**Council Reference:**  
**Your Reference: SSD8169 & MP09\_0028 Mod 5**

10 October 2018

**Tweed Shire Council comments on the proposed North Byron  
Parklands Cultural Event Site (SSD 8169) and modification of  
the Concept Plan (MP09\_0028 Mod 5)**

CIVIL WORKS PLAN

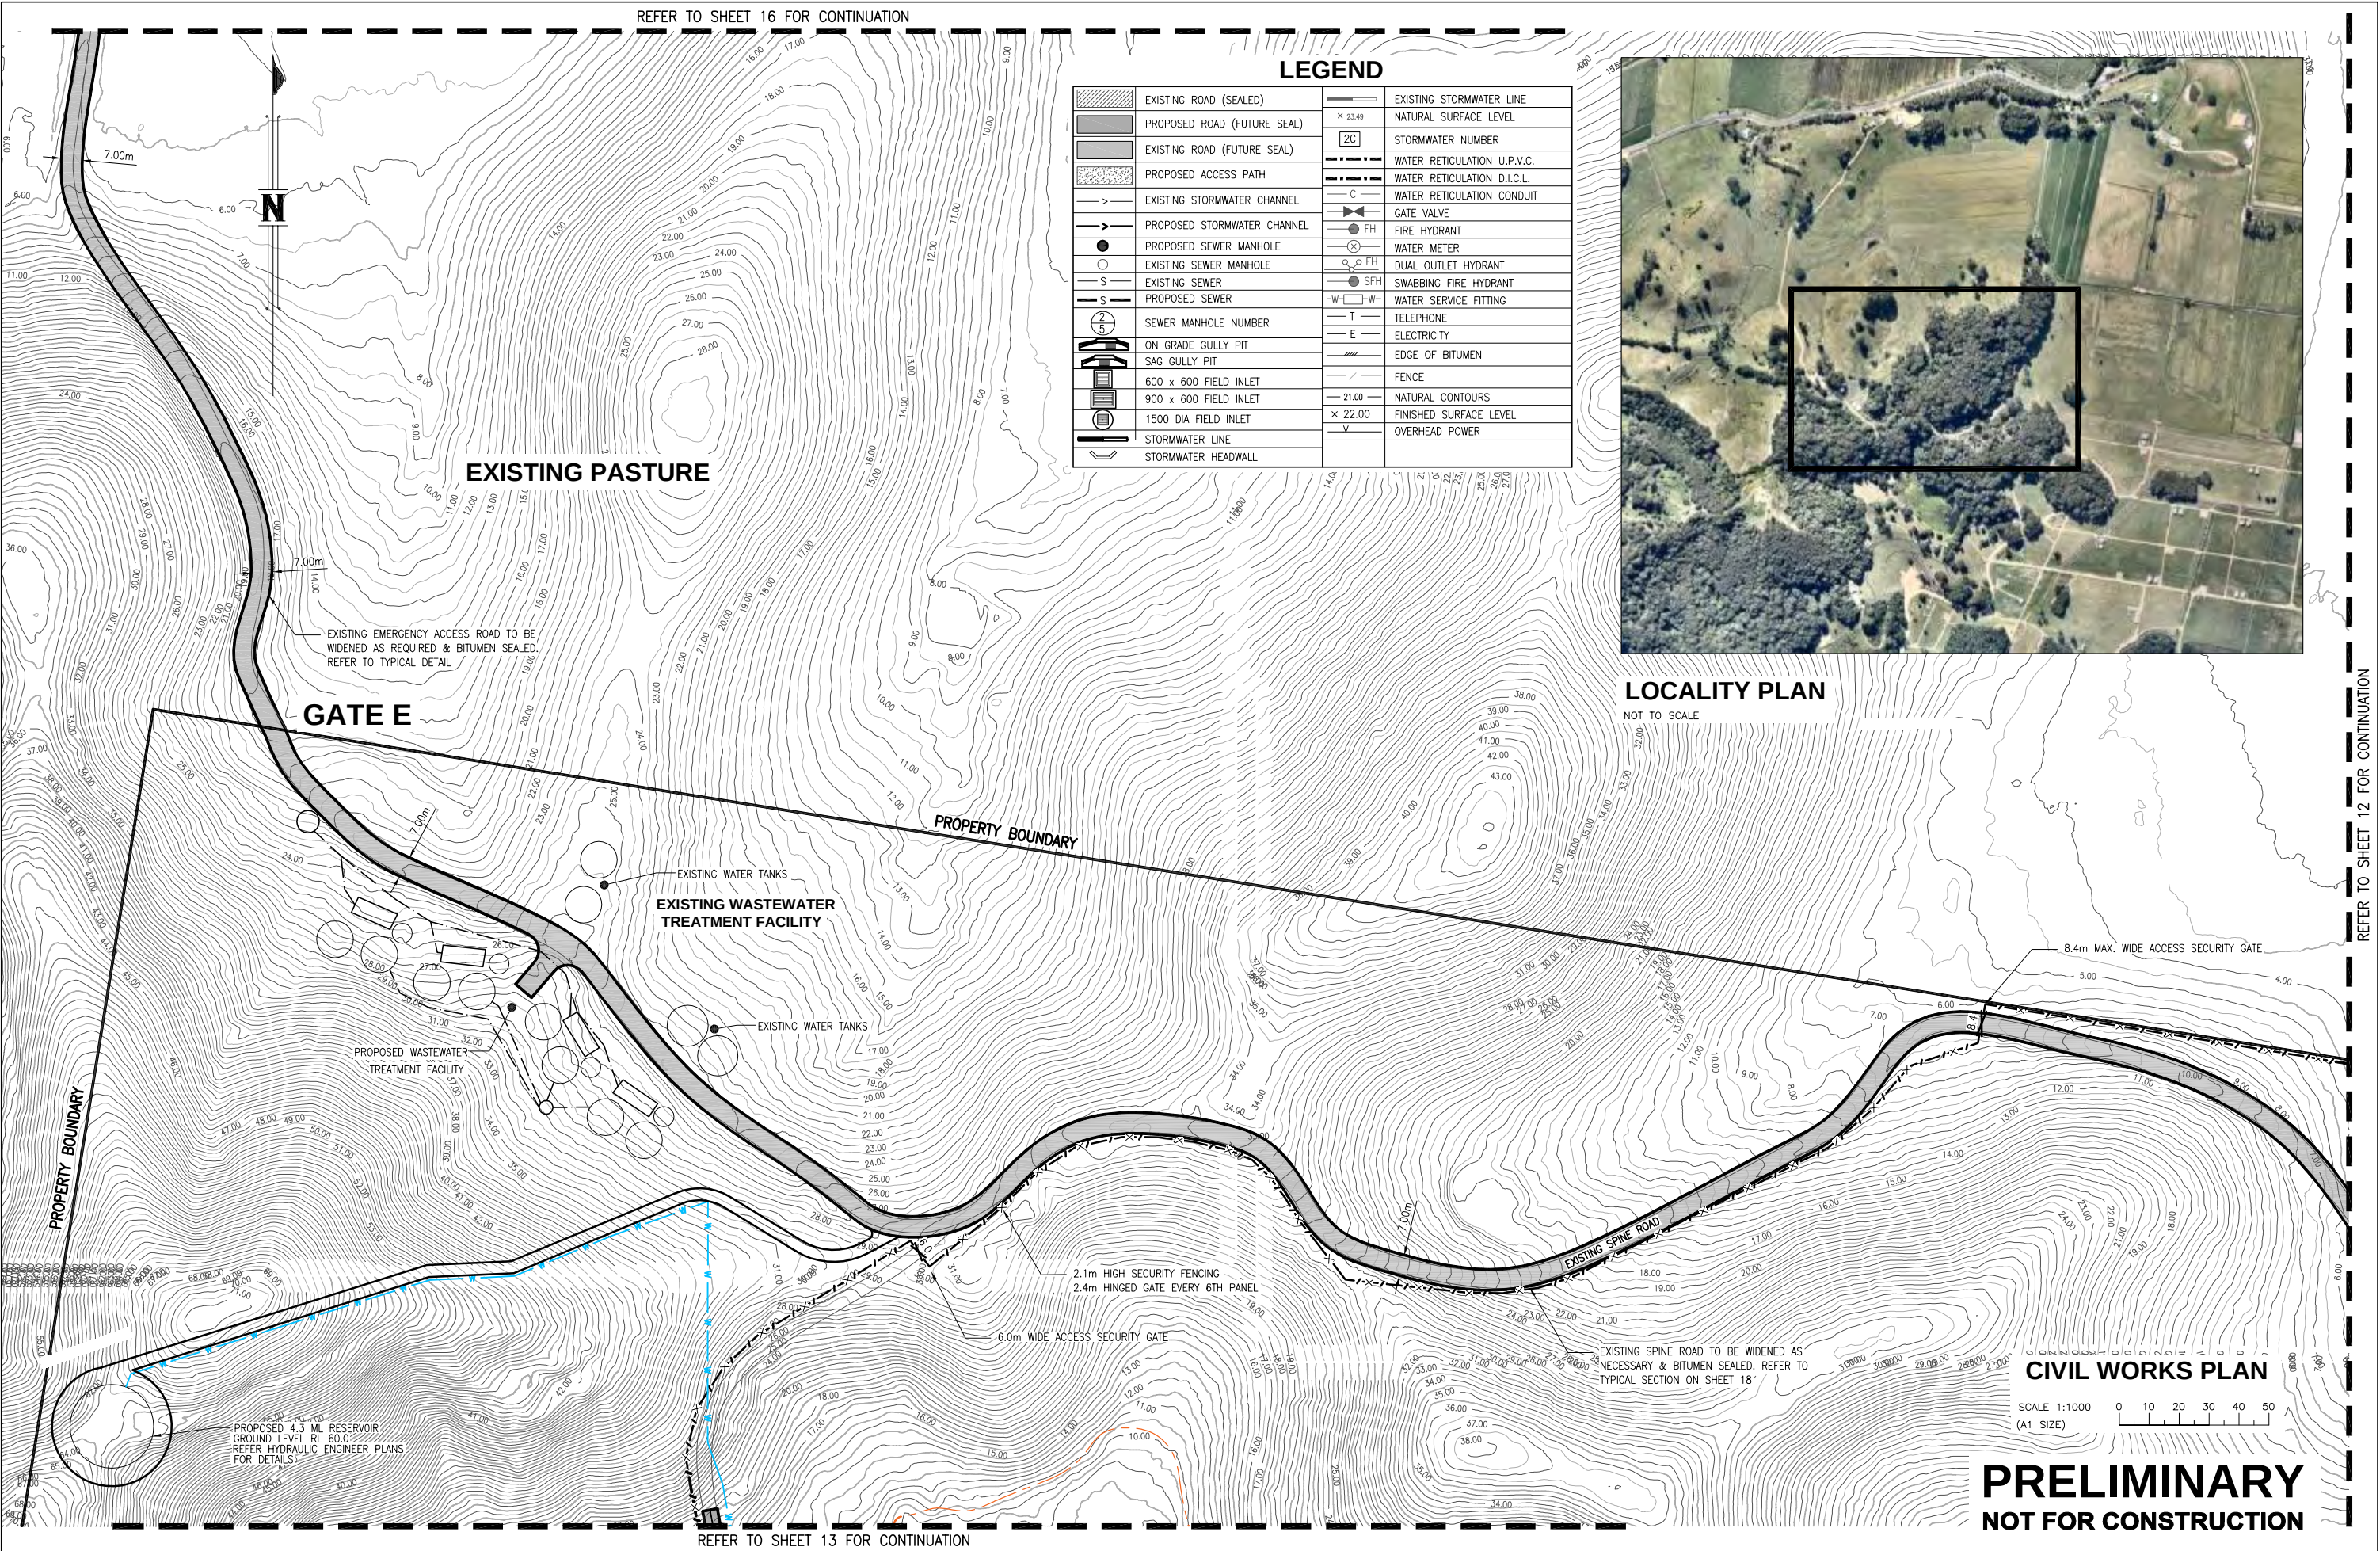
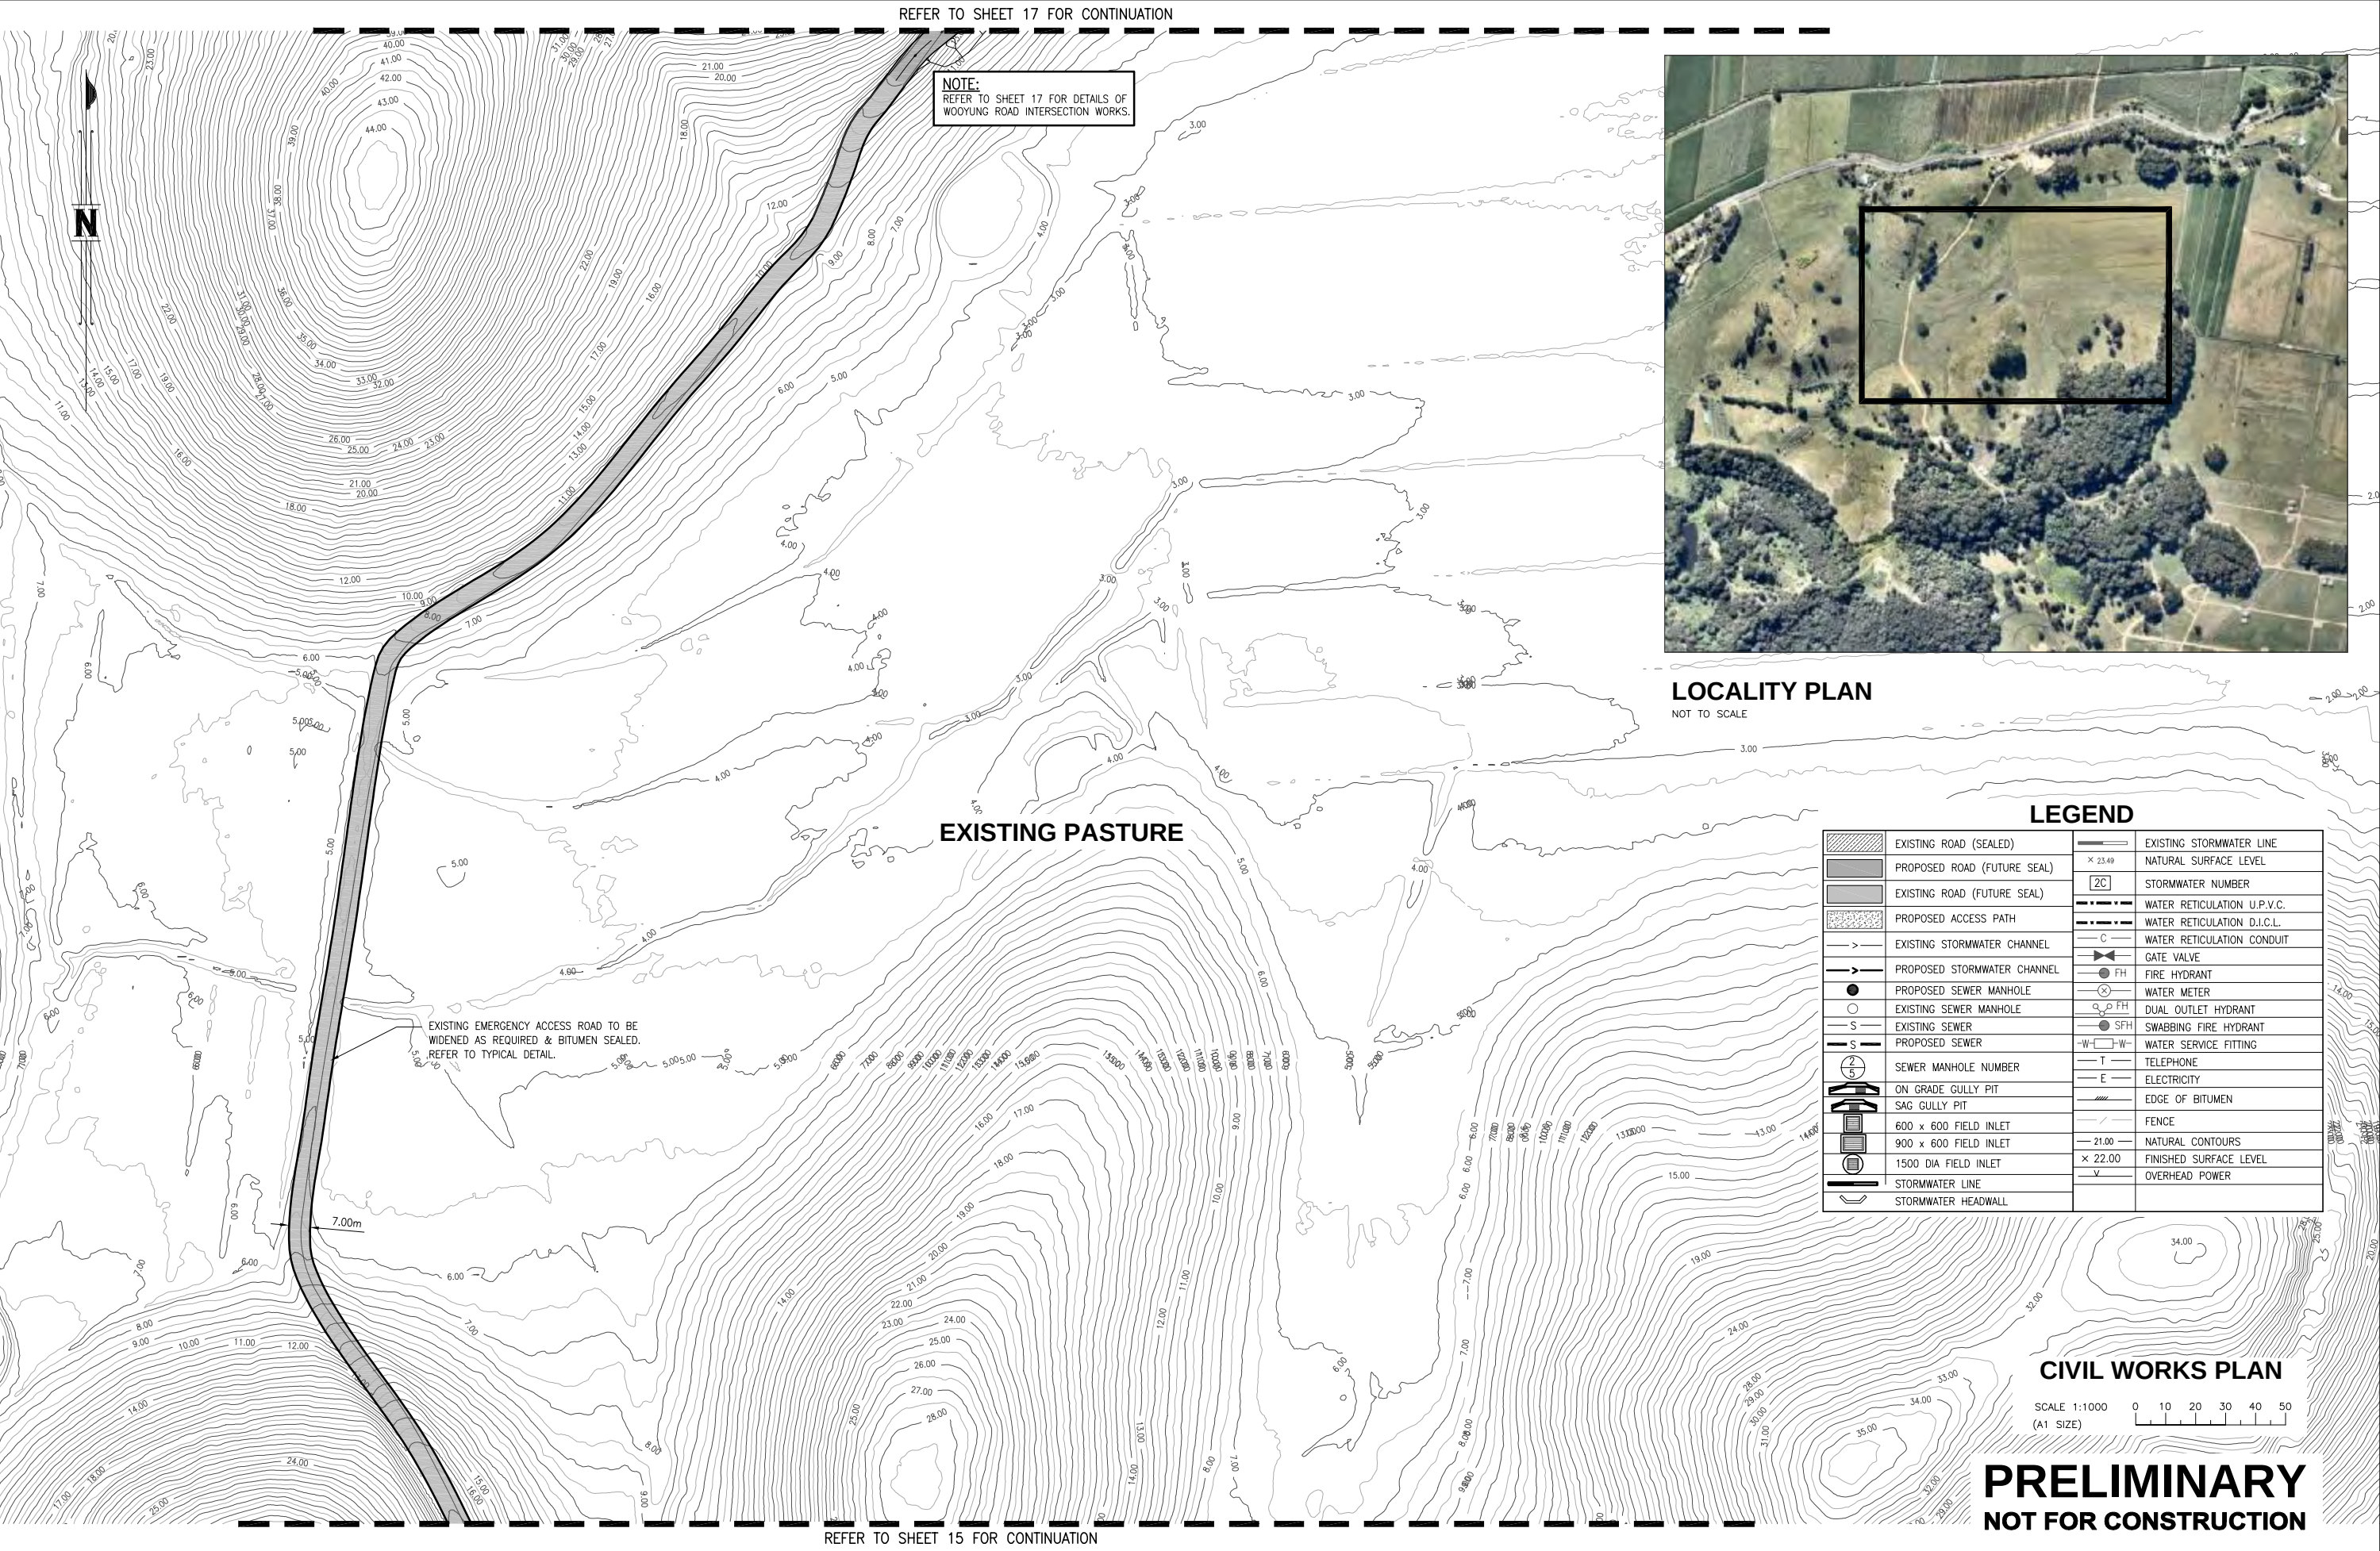
- a. The preliminary design for the new access to Wooyung Road (shown on Page 2 of *Appendix A - Revised Civil Design Plans*) identifies that fill may be required on adjacent private property, not the subject of this application.

Whilst the design is preliminary, it is recommended that a suitable condition be applied as noted below.

***Subject to the submission and approval from Tweed Shire Council through s138 Roads Act 1993, the proposed access and associated road widening is to be constructed wholly within Wooyung Road and designed to the Austroads Guides to Road Design for a BAR/BAL intersection and to Council's DCP Section A5 Subdivision Manual D1 Road Design.***
